Application for Planning Permission

Development: Change of use from supported living accommodation to 10 No residential units (Use Class C3), proposed rear extension following demolition of detached building, fenestration changes and associated works. This application is in CIL Zone 4 (Zero Rated) as other development.

Location: Milton Lodge 192 Hawthorn Road Bognor Regis PO21 2UX

Main building - Second Floor  
1:50

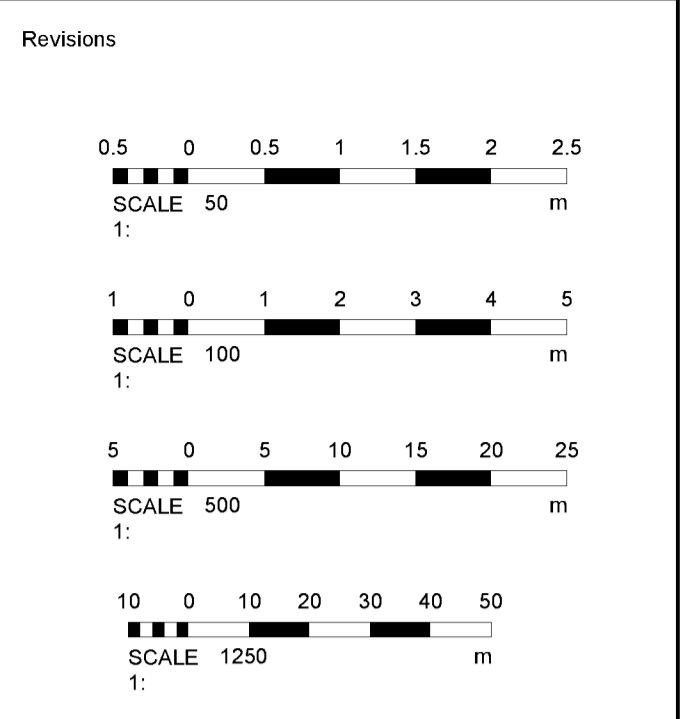
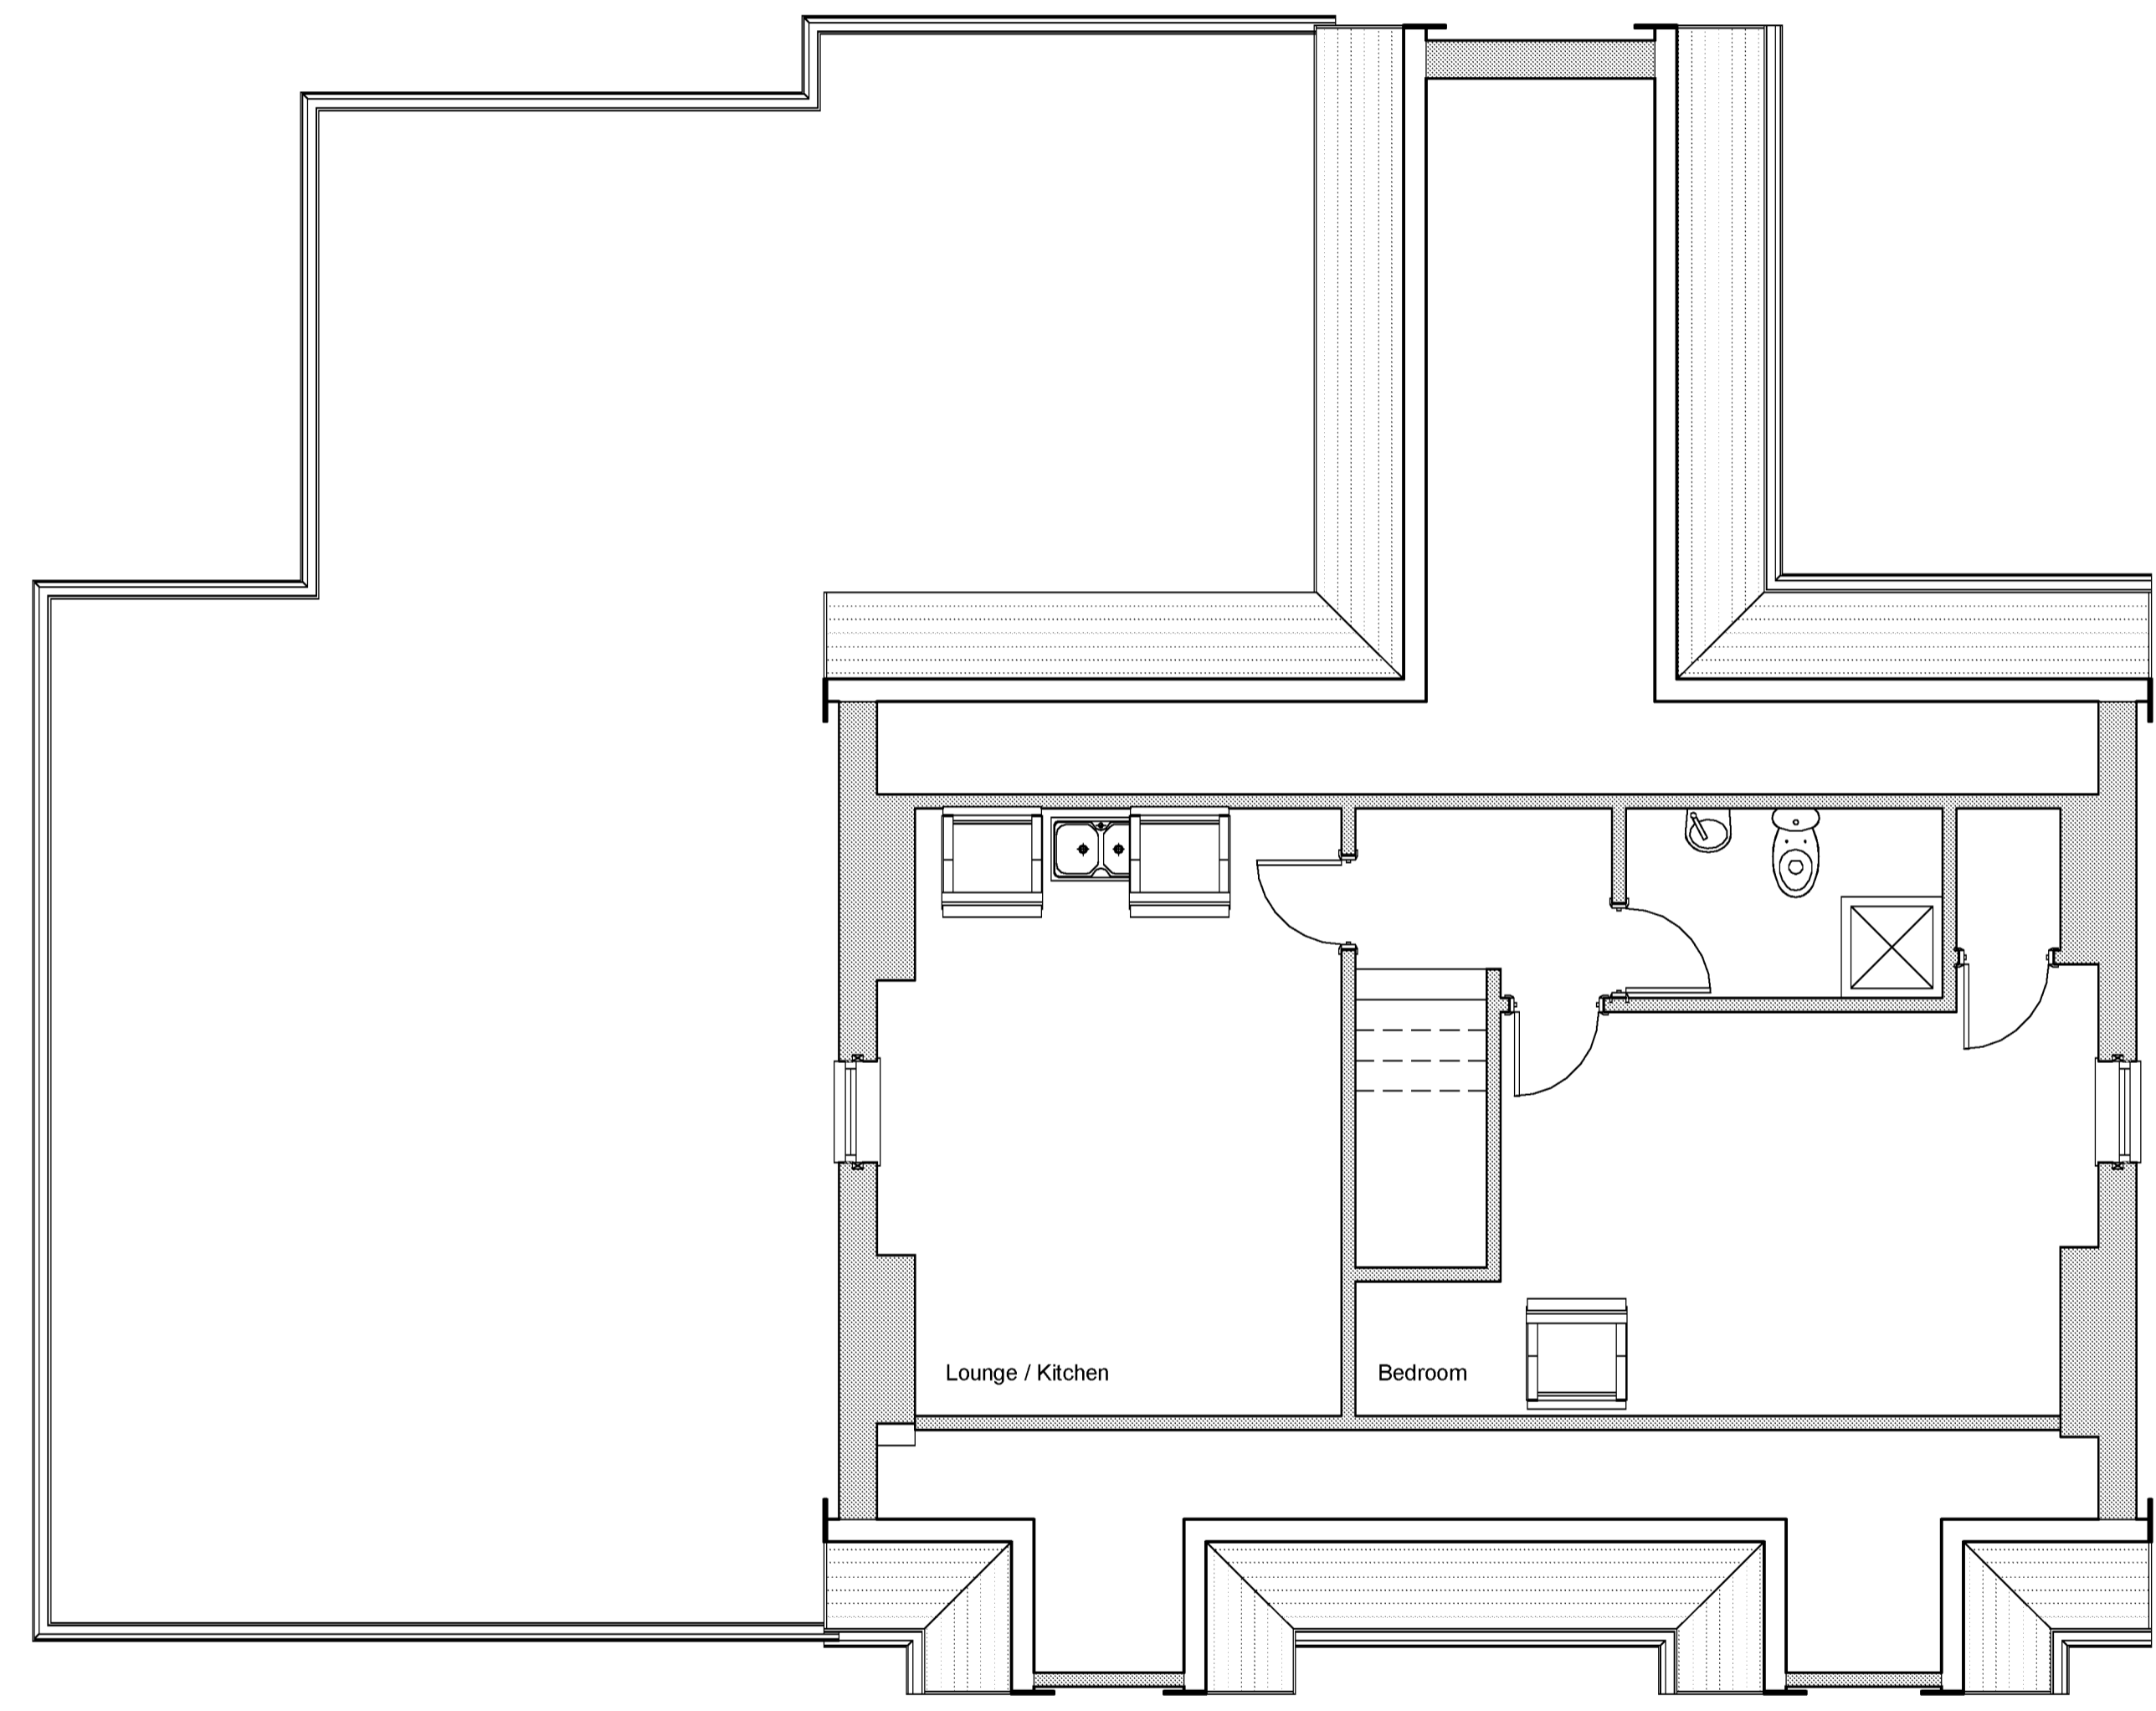
Please show the 2 No roof lights on the second floor plan.

Detached Unit ( former communal area ) - Ground Floor

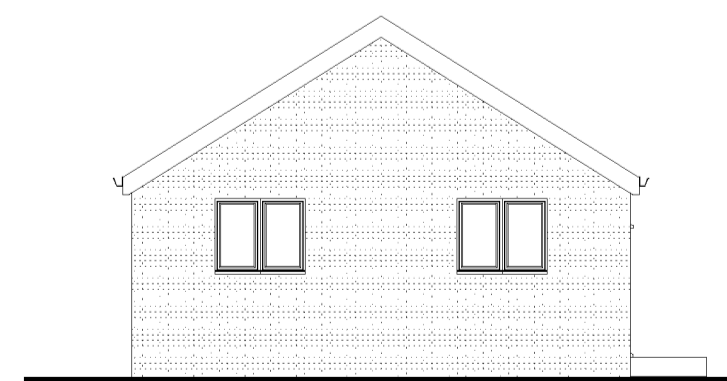
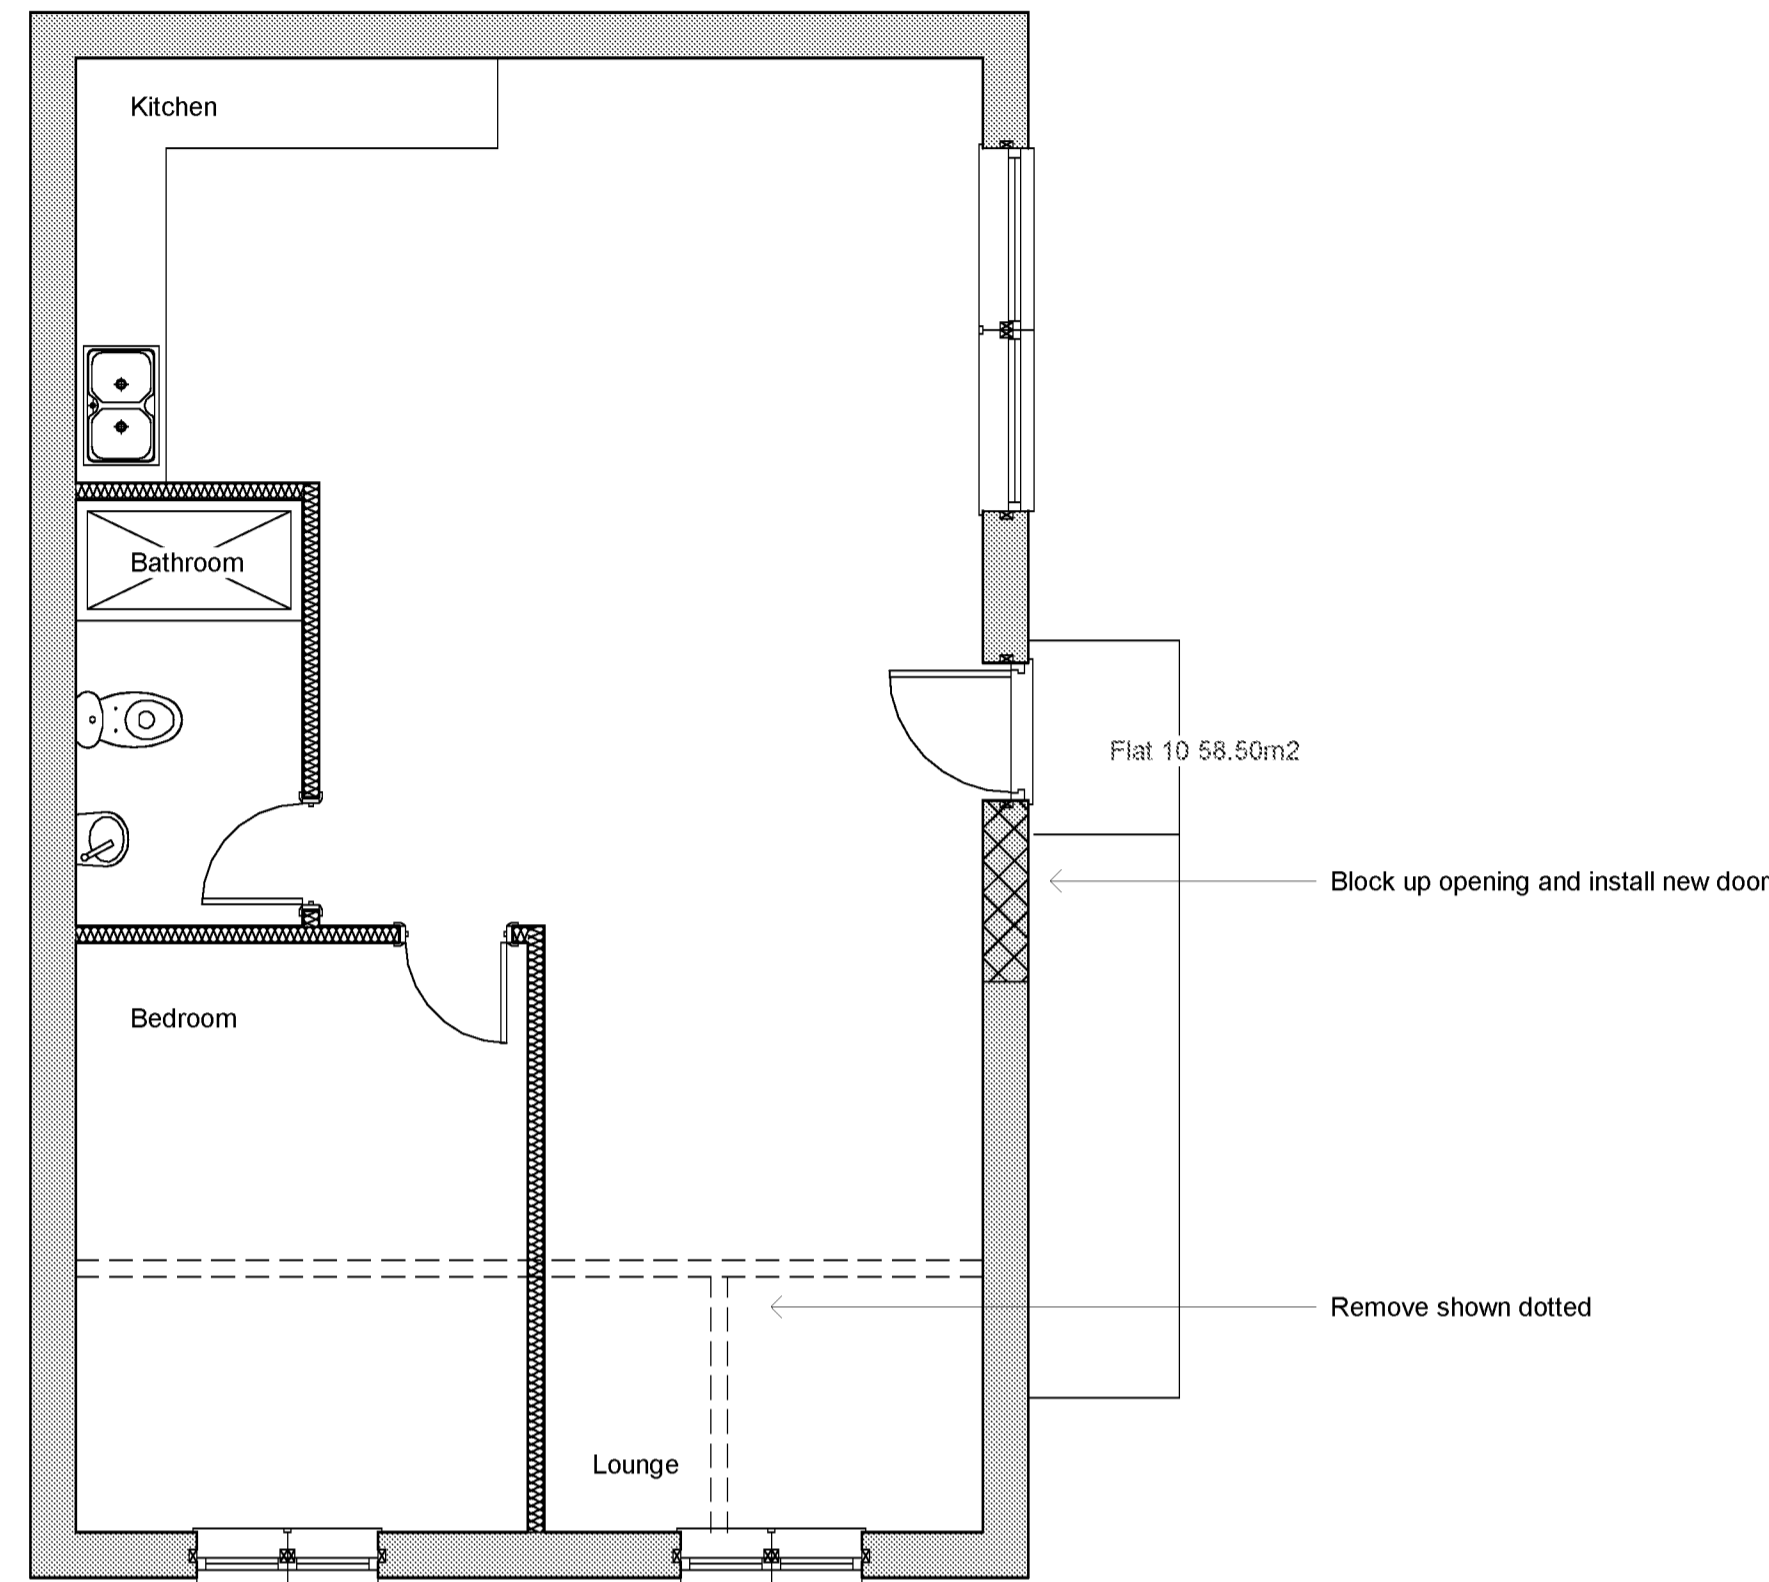
Please confirm the use of the building being demolished.
